CITY OF ALBUQUERQUE

February 21, 2017

RE: **GAHP Silver Downtown**
800 Silver SW
Grading Plan Engineer's Stamp Date: 1/30/2017
Hydrology File: K13D013

Based upon the information provided in your submittal received 2/10/17, the Grading Plan is not approved for Building Permit. The following comments need to be addressed for approval of the above referenced project:

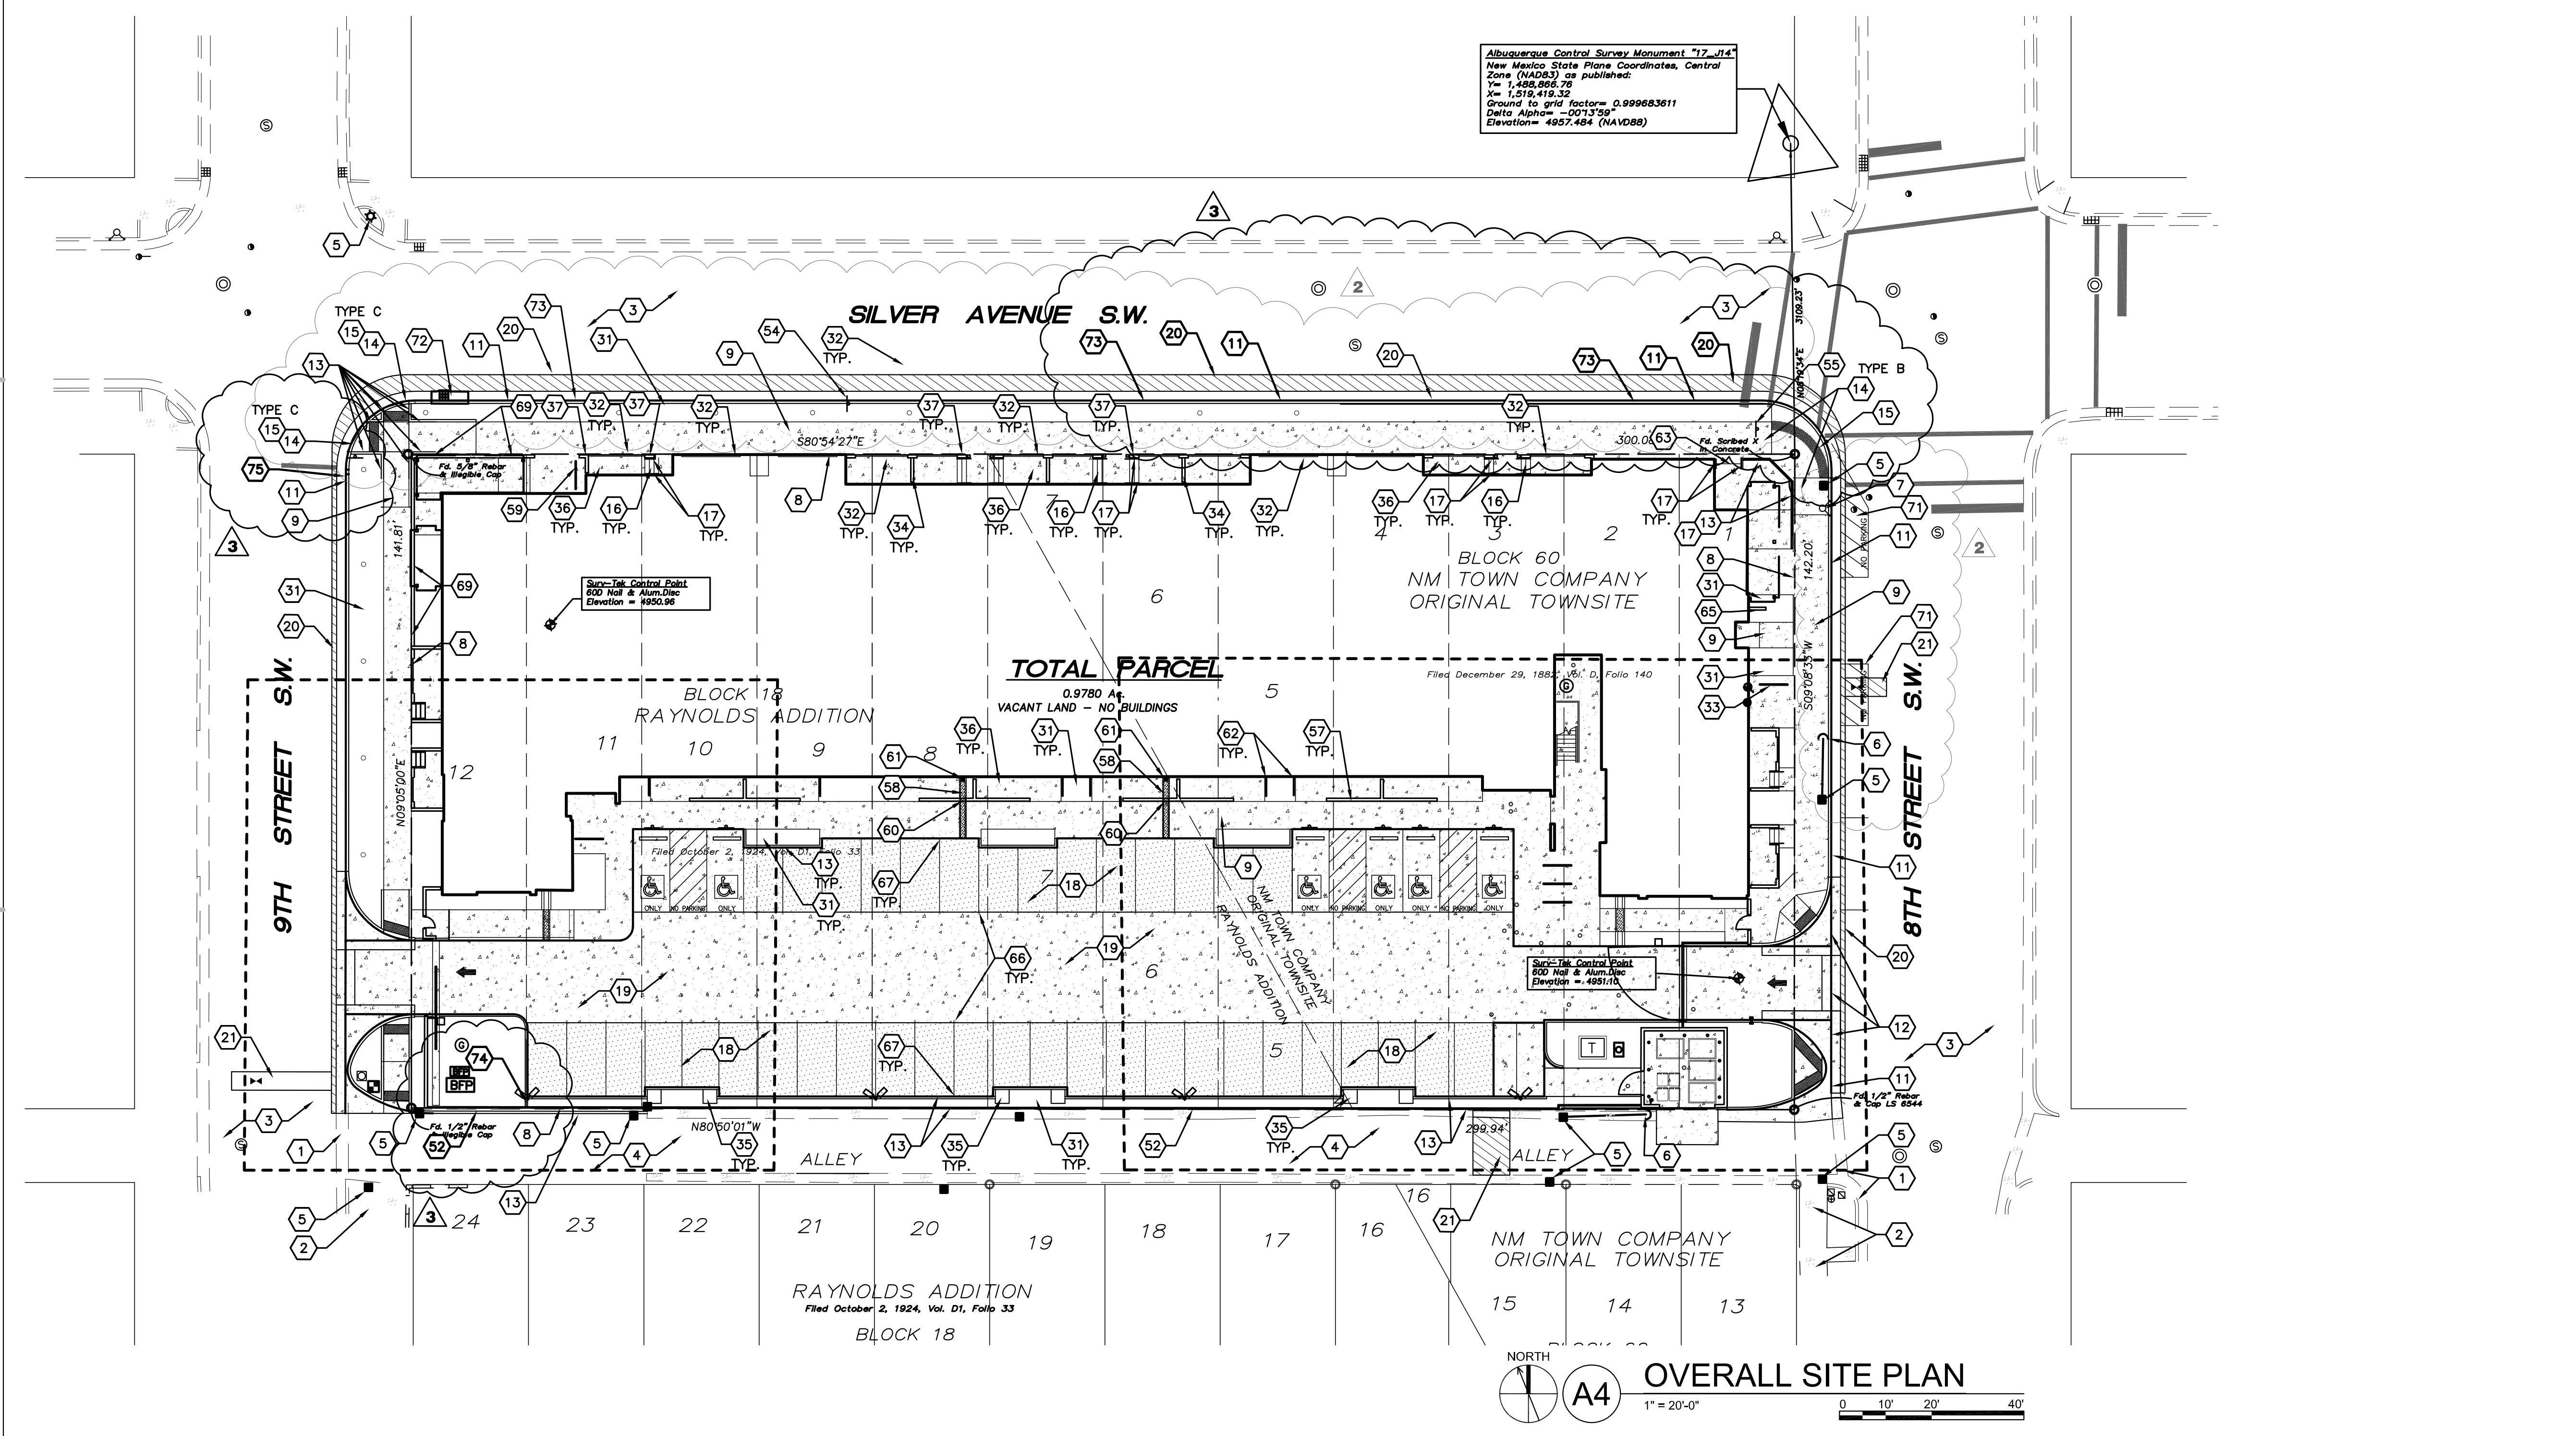
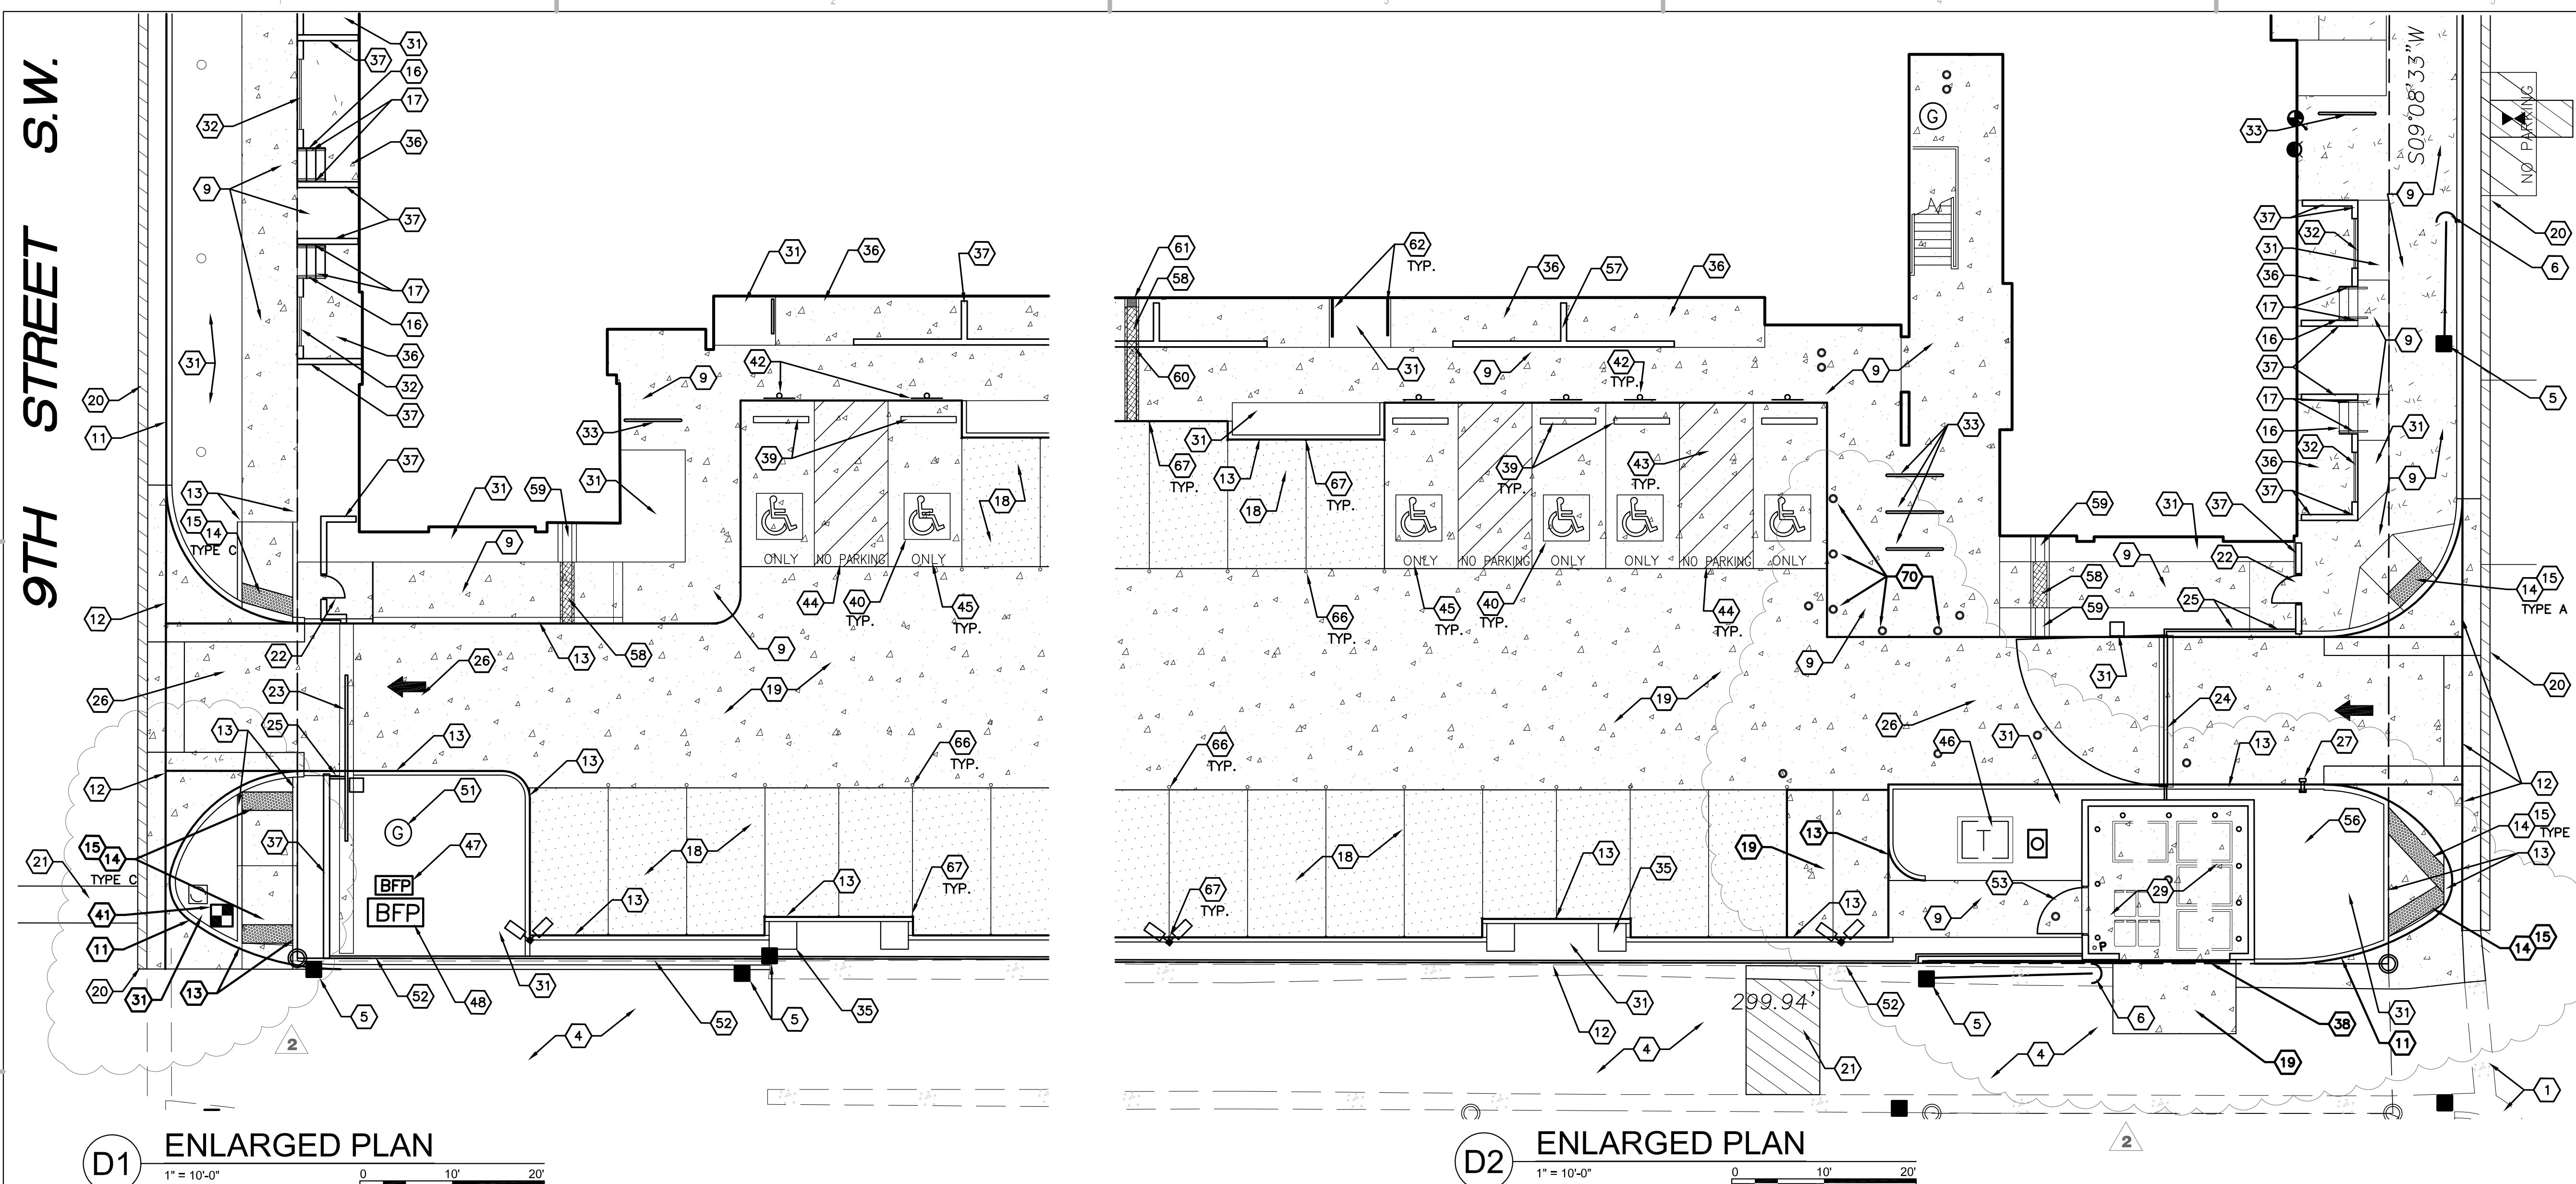
1. The drainage sheets still state conceptual and do not appear to be part of the construction plans. Remove conceptual references to include as part of the submittal.

A4 OVERALL GRADING PLAN
1" = 20'-0"

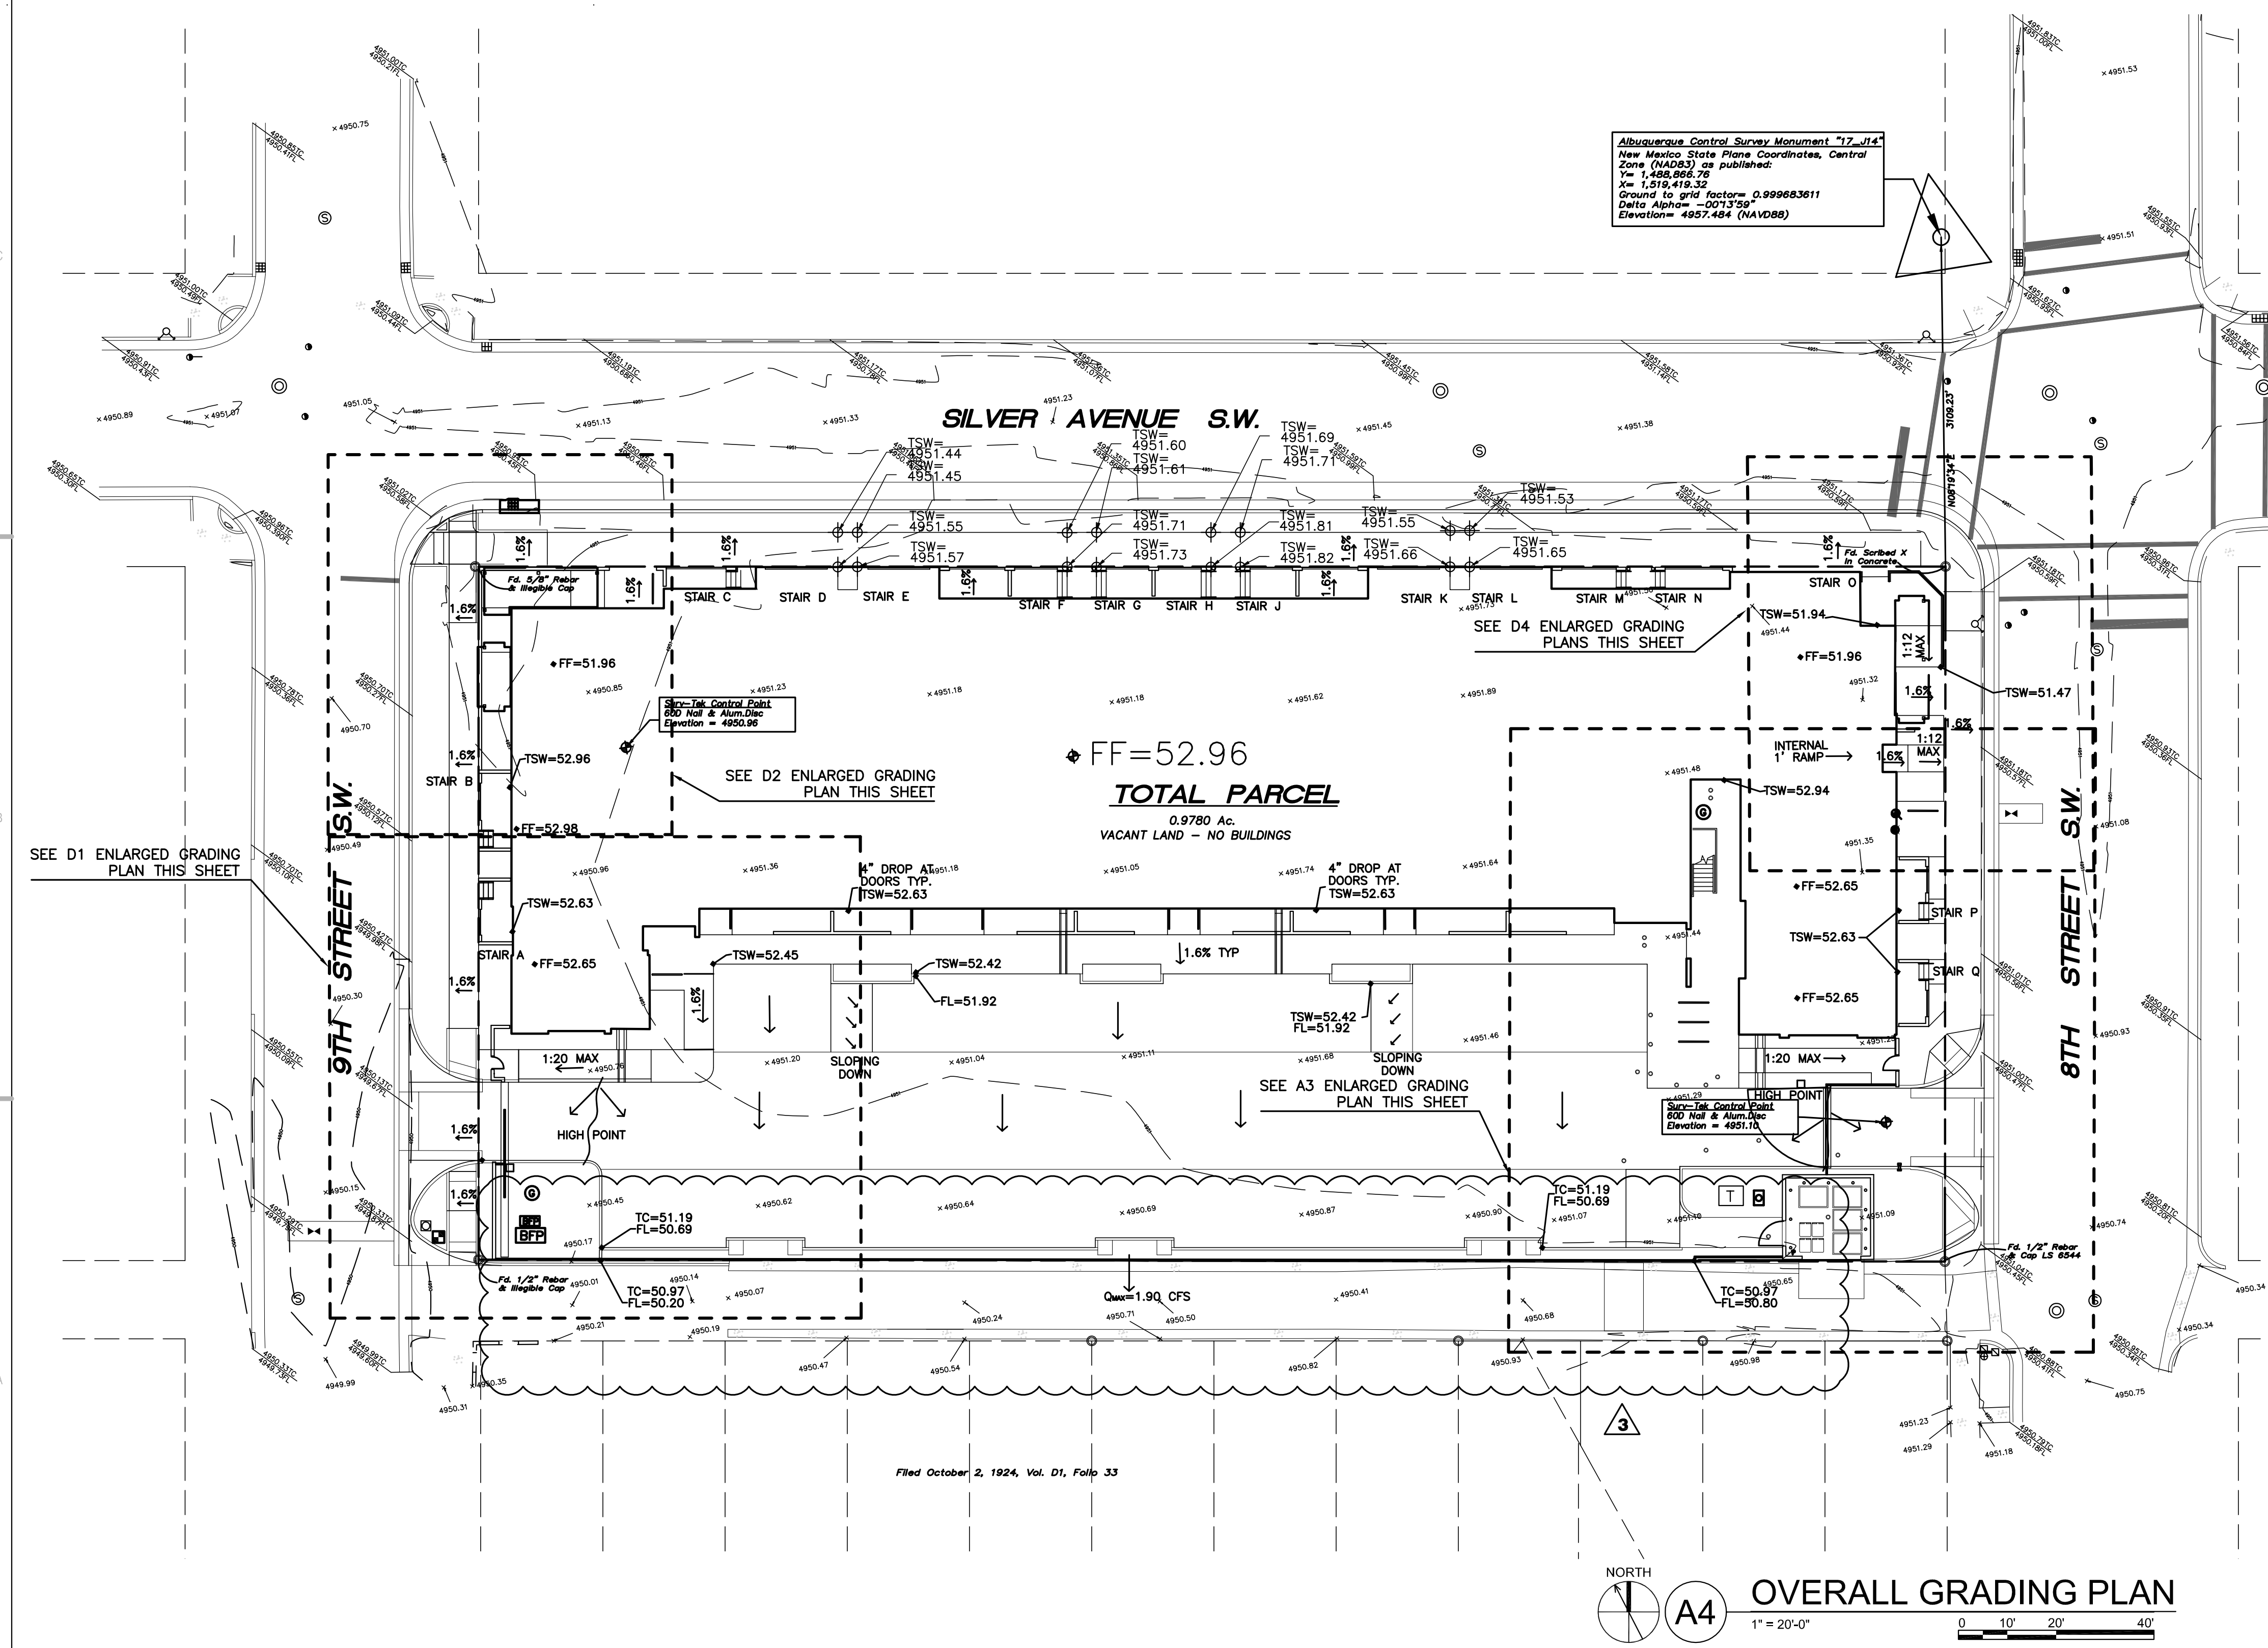
3. There is a reference to a constrictor plate for the draining the parking lot to the ally, but none is shown on the construction plans. Provide location and details for this.

6. The ponding volume for the parking area does not account for the running slope across the parking lot toward the ally. This means the gravel areas will not retain a uniformly deep 2" of water.

4. It was agreed during the review for SPBP that the wide buffer between the back of curb and the edge of sidewalk would be used to help mitigate nuisance ponding on Silver and 9th Street, by including new curb cuts on the ex. curb. This would help the site achieve the capture of the first flush volume. It needs to be shown on the plan.

5. The 2" depression in the sidewalk buffer does not account for the running slope along top of curb and along the sidewalk. This means the depression will not retain a uniform 2" deep pool. This area needs to be supplemented with a 5:1 gravel filled swale and curb cuts with shallow ponding to allow in flows from Silver and 9th Street.
